Attachment A

Response to Request for Additional Information from DPIE (SSD 8784)

**Through Site Link**

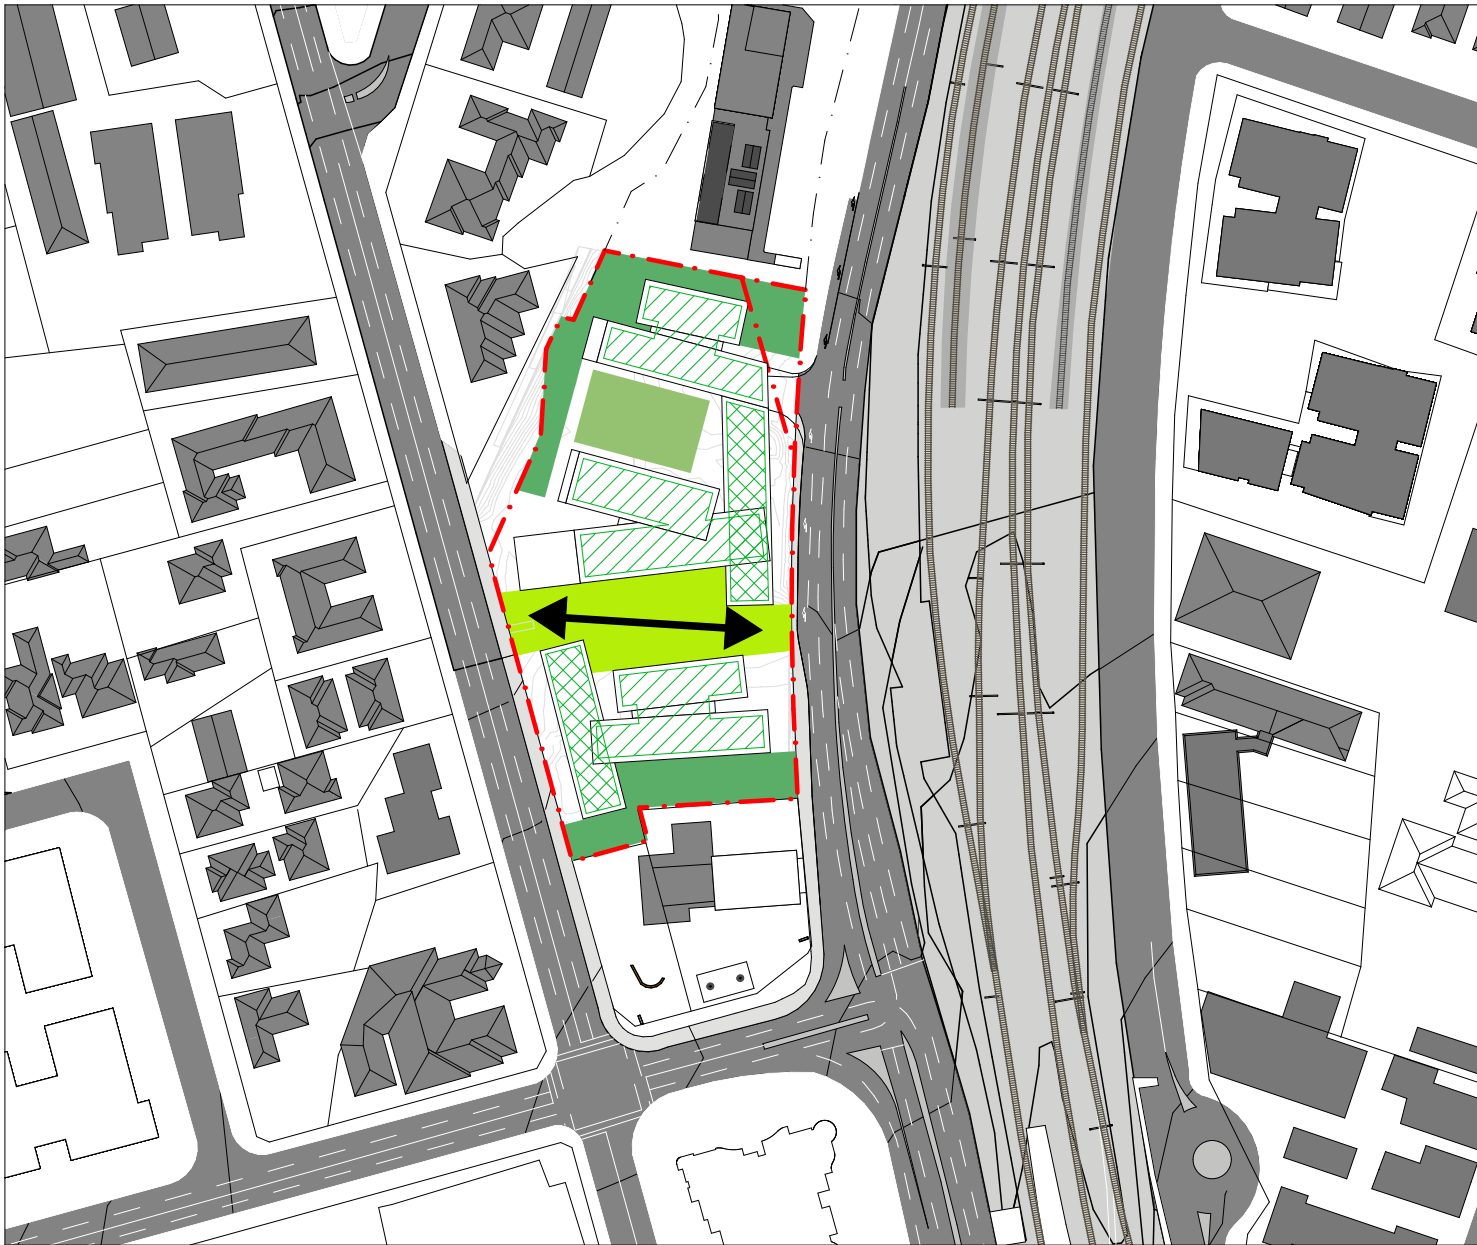
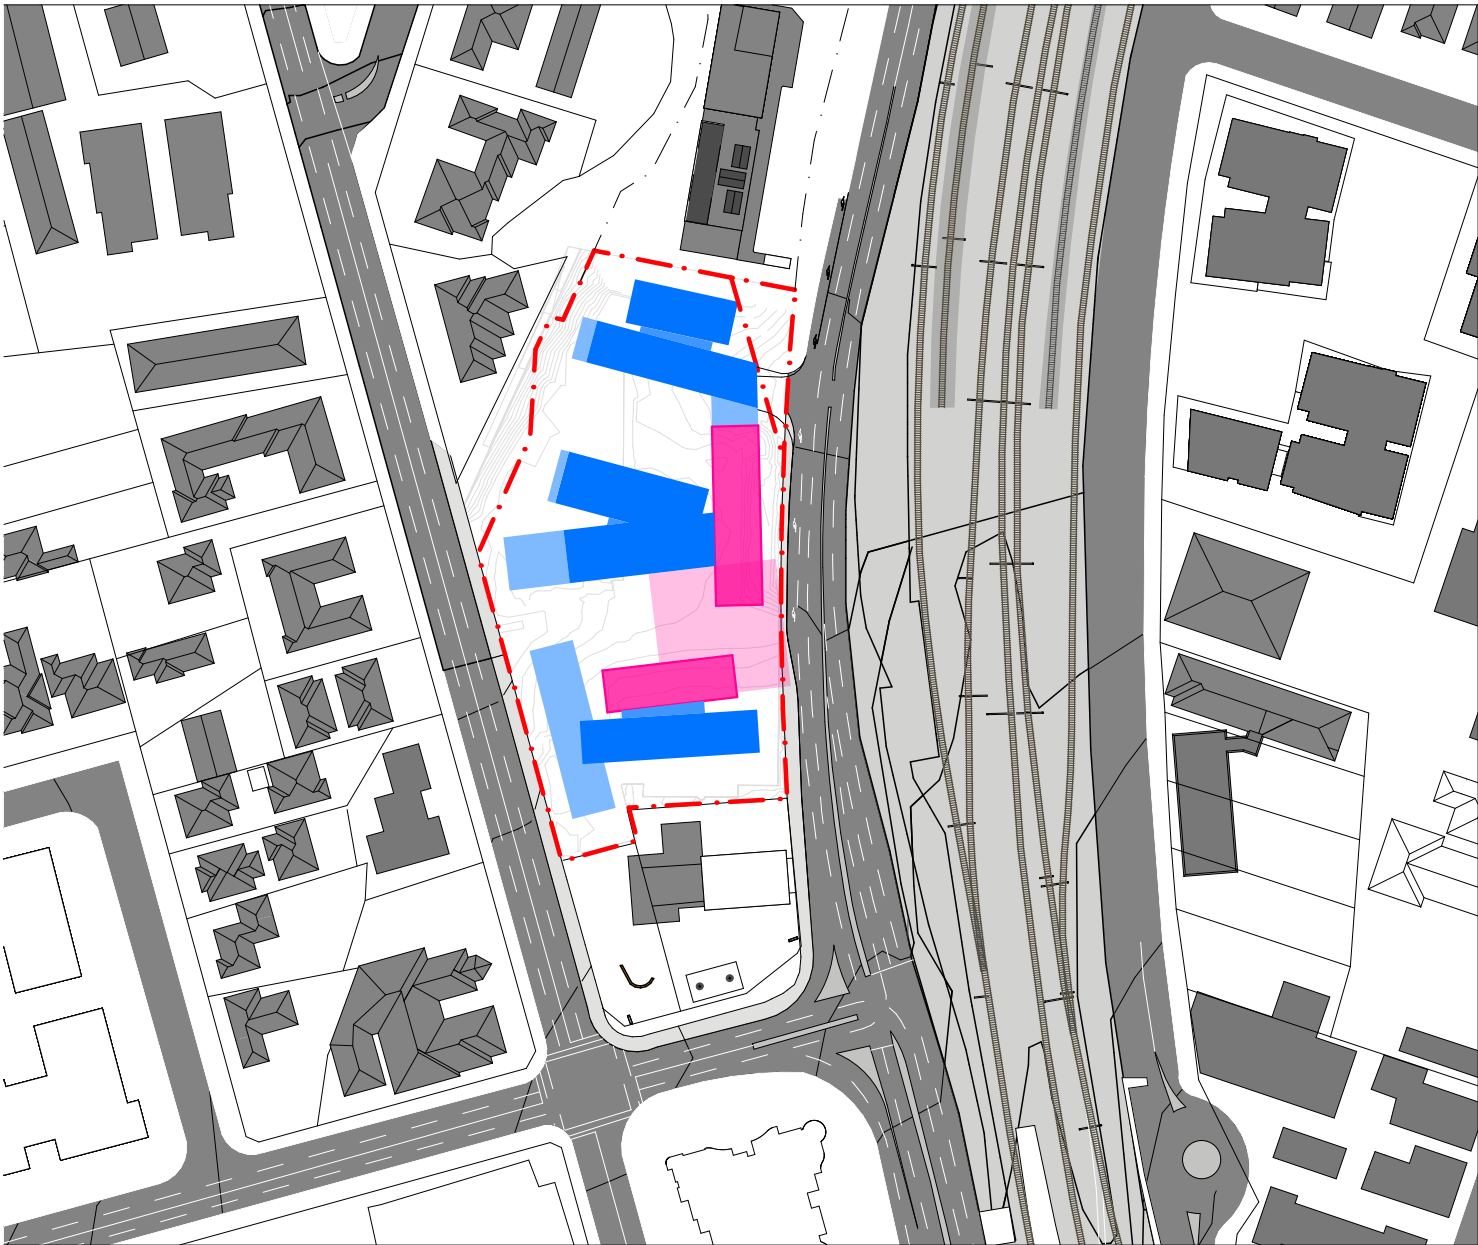
<ul style="list-style-type: none"> • <i>Clarify the through-site link design capacity and consider safety for cyclists.</i> 	<p>The pedestrian through-site link has been designed to provide a publicly accessible link between Beecroft Road and Ray Road. The through-site link will facilitate convenient movement and connectivity across the site for both residents and the general public.</p> <p>The steeper gradient at the western extent of the through-site link incorporates sharp, hairpin turns along the pathway and stairs which will discourage cyclists to use the link as a shortcut between Ray Road and Beecroft Road. Therefore, the through-site link does not include the provision of a dedicated cycleway and has been designed to ensure cyclists will need to dismount in order to navigate across the site. The inclusion of fixed furniture, trees and planter boxes, various textures and bollards will further encourage cyclists to dismount prior to entering the</p>

Request for Information	Response
	<p>through-site link. This is to ensure the ongoing safety of both cyclists and pedestrians and to maintain a pedestrian-friendly environment through the development site.</p> <p>Further, the draft Parramatta Bike Plan 2017-2037 indicates there will be a future on-road painted bicycle lane along Ray Road that will provide a linkage to various regional connections. Cyclists will, therefore, be able to travel efficiently along Ray Road without the reliance of a shortcut through the development site. Cyclists wishing to travel at faster speeds will likely avoid the through-site link and make use of the existing and (future) dedicated cyclist infrastructure surrounding the site.</p>
Deep Soil Zones	
<ul style="list-style-type: none"> Consider providing additional deep soil zones within the widened pedestrian through-site link to provide improved amenity and visual privacy for residential uses. 	<p>Additional deep soil zones to provide shade and amenity have been incorporated within the through-site pedestrian link, including two separate deep soil zones of 41 m² and 37 m². These areas are shown on updated Plan 4.03 (Attachment B).</p> <p>In total, the concept proposal now provides 1,880 m² of deep soil zones across the development site, which equates to 18.5% of the site area. This exceeds the minimum deep soil zone requirement set out in the Apartment Design Guide (DPE, 2015) which recommends 7% of the total site area (for sites greater than 1,500 m²) to consist of deep soil zones.</p>

INDICATIVE IMAGE SHOWING ENTRY LOBBY WITH NATURAL LIGHT, SEATING, AND LANDSCAPING. SOURCE: SJB ARCHITECTS - TAPESTRY

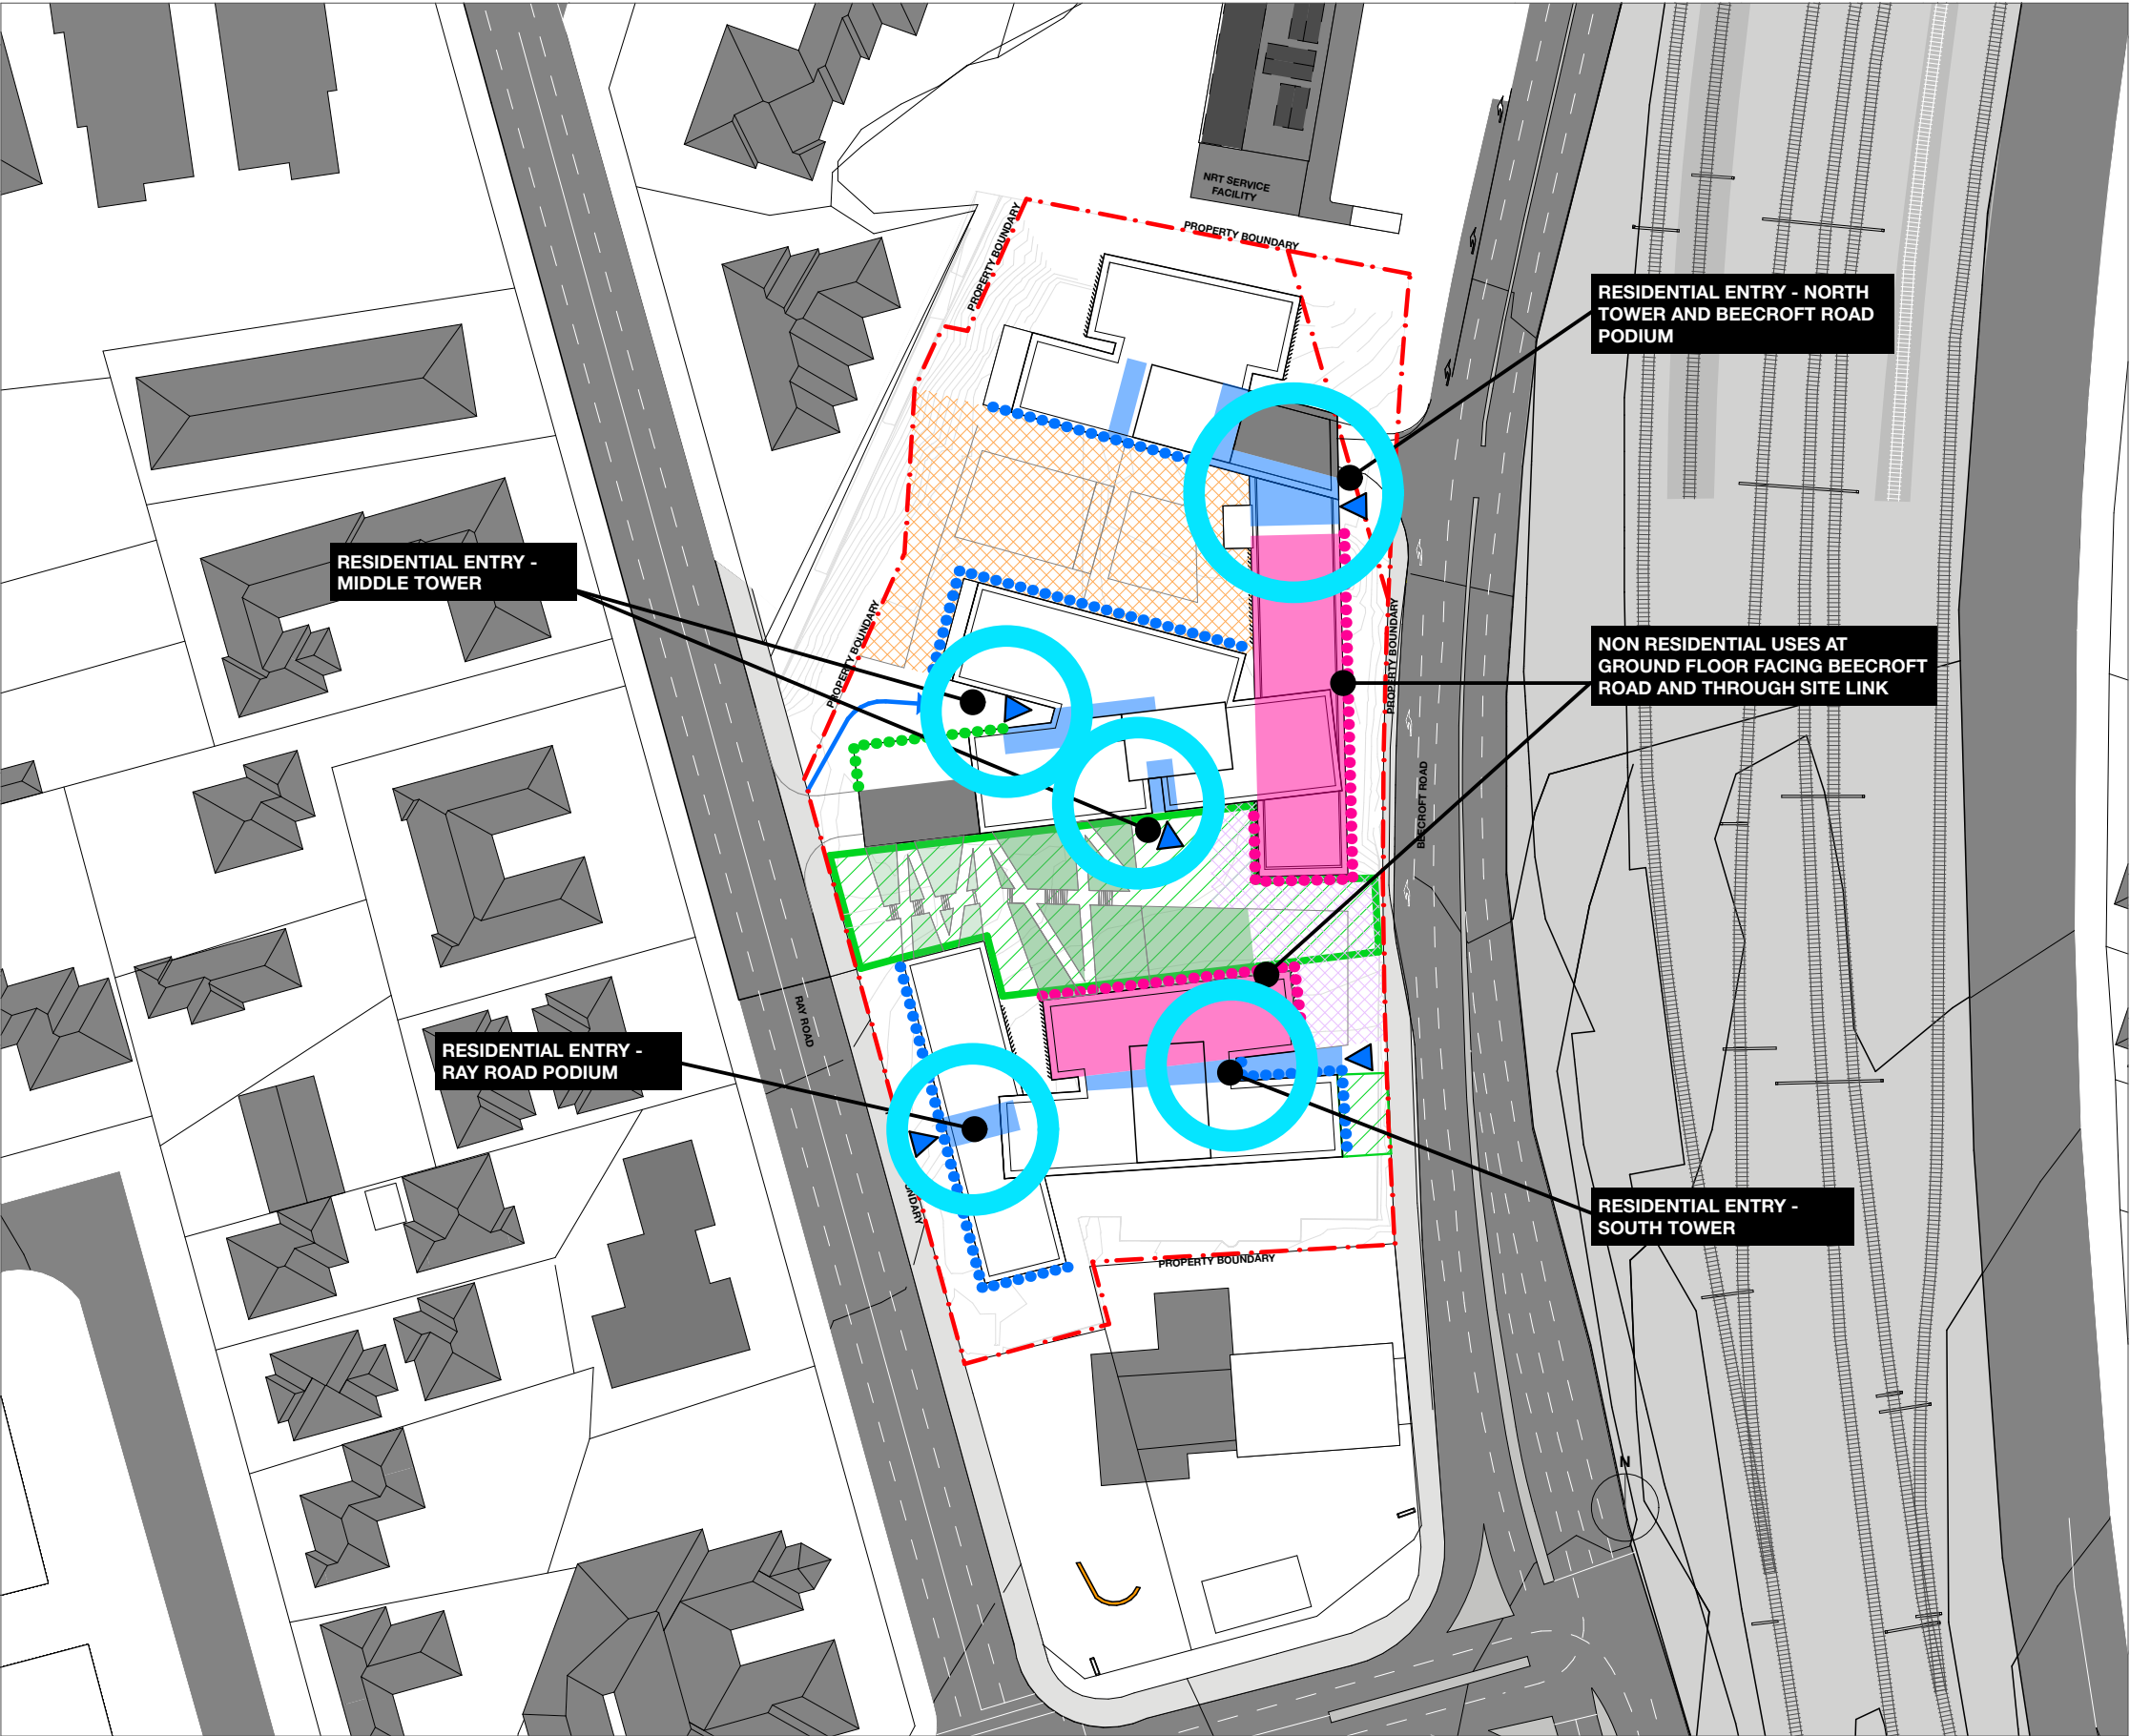
Request for Information	Response
<ul style="list-style-type: none"> o <i>building identity and the provision of high quality pedestrian access to residential lobbies</i> 	<p>The residential lobbies will be designed to:</p> <ul style="list-style-type: none"> • provide a clear building identity • be inviting with access to natural daylight • be located with good visibility from the public domain • incorporate landscaping and plantings • be spacious and incorporate furniture for visitors in waiting areas • make use of durable materials and finishes of a high quality • incorporate areas for mailboxes and deliveries. <p>The location of the future residential lobbies is shown on Plan 3.09 (Attachment B). Examples of potential treatment options for the residential lobbies are shown below. The design of the residential lobbies will be further refined as part of the future DA/s for the site.</p> <div data-bbox="823 940 1142 1255"> </div> <p>INDICATIVE IMAGE SHOWING ENTRY LOBBY WITH NATURAL LIGHT, SEATING, LANDSCAPING. SOURCE: SJB ARCHITECTS - TAPESTRY</p> <div data-bbox="1325 724 1818 1235"> </div> <p>INDICATIVE IMAGE SHOWING ENTRY LOBBY WITH NATURAL LIGHT, SEATING, AND LANDSCAPING. SOURCE: TURNER ARCHITECTS - WOOLAWARE</p>

# BASEMENT TREATMENT

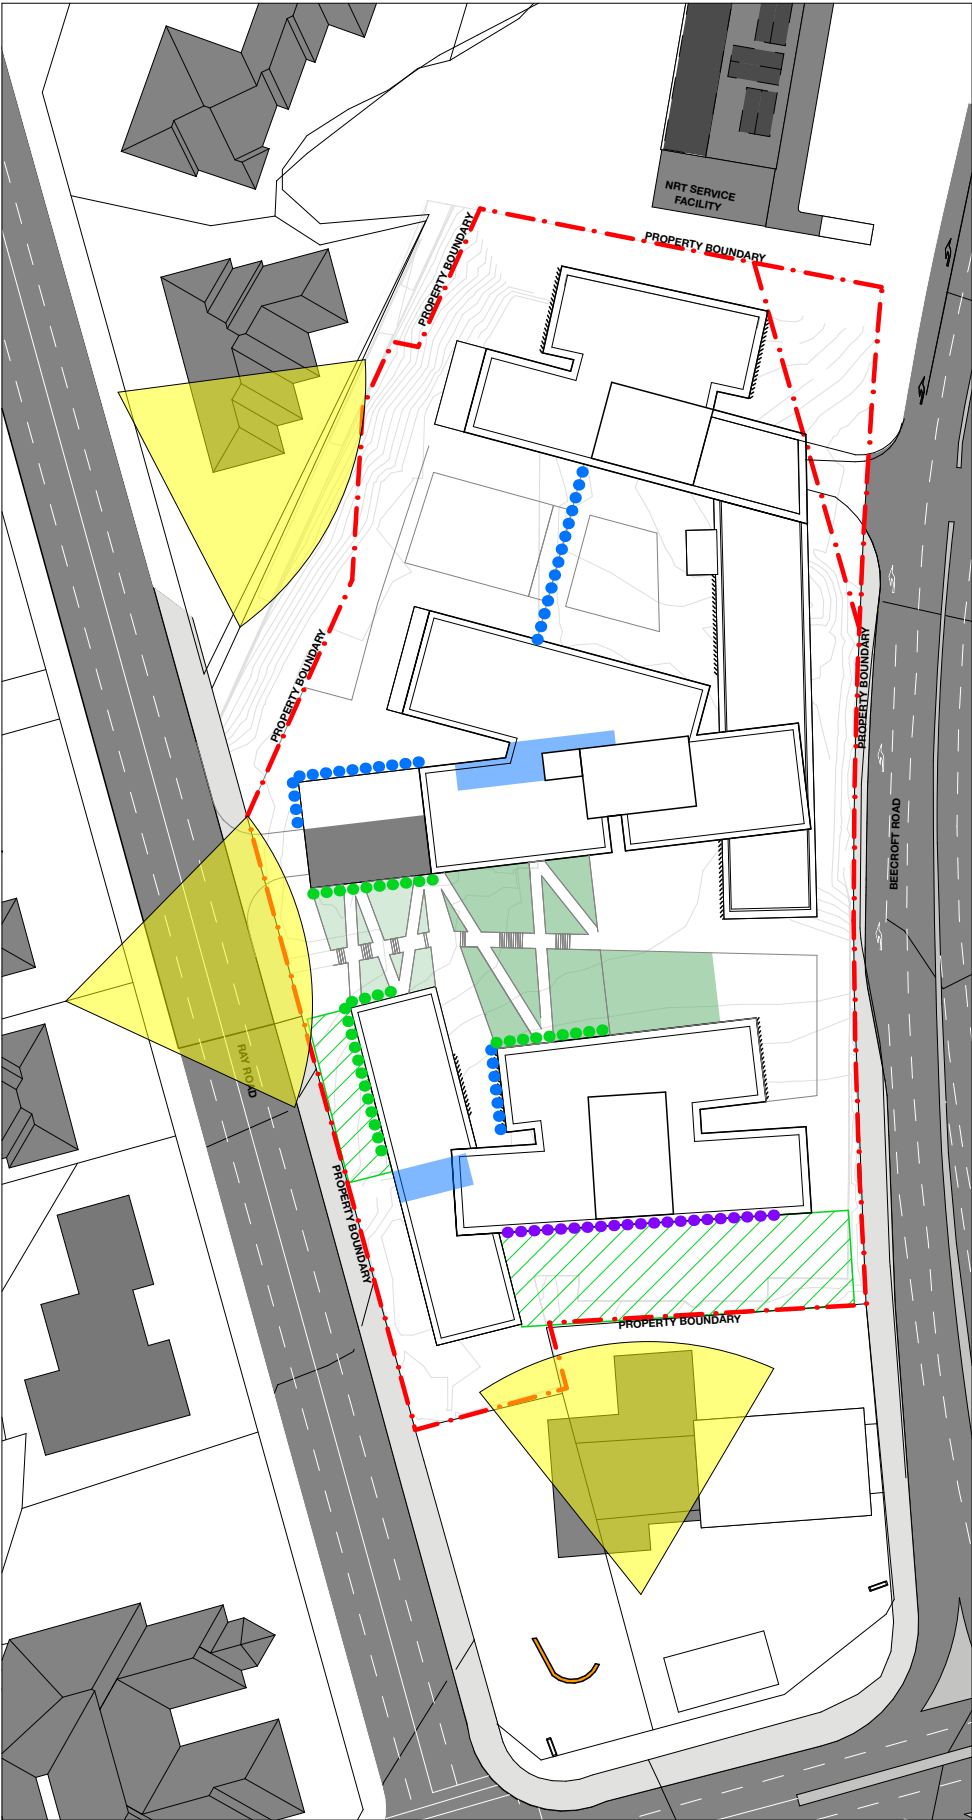
Request for Information	Response
Design Guidelines	
<ul style="list-style-type: none"> • <i>Provide additional design guidance for landscaping and open space in relation to:</i> <ul style="list-style-type: none"> ○ <i>treatment of basement protrusions and aboveground car parking</i> 	<p>Where basement walls are located above ground level, treatments will be incorporated in order to provide a satisfactory visual outcome and a positive contribution to the public domain. Potential treatments may include public art, stone or masonry facades, vegetation screening and green walls. Suitable treatments for this particular site will be explored in greater detail as part of the future stage development application/s (DAs) for the site.</p> <p>The location of above ground basement walls is shown on Plan 3.10 (Attachment B). Examples of potential treatment options for the basement protrusions and indicative basement sections are shown in the figures below.</p>  <p>INDICATIVE IMAGE SHOWING TREATMENT TO ABOVE GROUND BASEMENT WALLS WITH PUBLIC ART, ARCHITECTURAL TREATMENT, LANDSCAPING SOURCE: TURNER ARCHITECTS - CENTRALE, NORTH RYDE</p>

Request for Information	Response
	<div data-bbox="823 339 1688 826">  </div> <div data-bbox="823 833 1453 894"> <p>INDICATIVE IMAGE SHOWING TREATMENT TO ABOVE GROUND BASEMENT WALLS WITH ARCHITECTURAL TREATMENT AND LANDSCAPING SOURCE: TURNER ARCHITECTS - WASHINGTON PARK</p> </div> <div data-bbox="823 911 1688 1333">  </div> <div data-bbox="823 1339 1453 1391"> <p>INDICATIVE IMAGE SHOWING TREATMENT TO ABOVE GROUND BASEMENT WALLS WITH SET BACK NATURAL VENTILATION TO BASEMENT SOURCE: SMART DESIGN - ARLINGTON</p> </div>
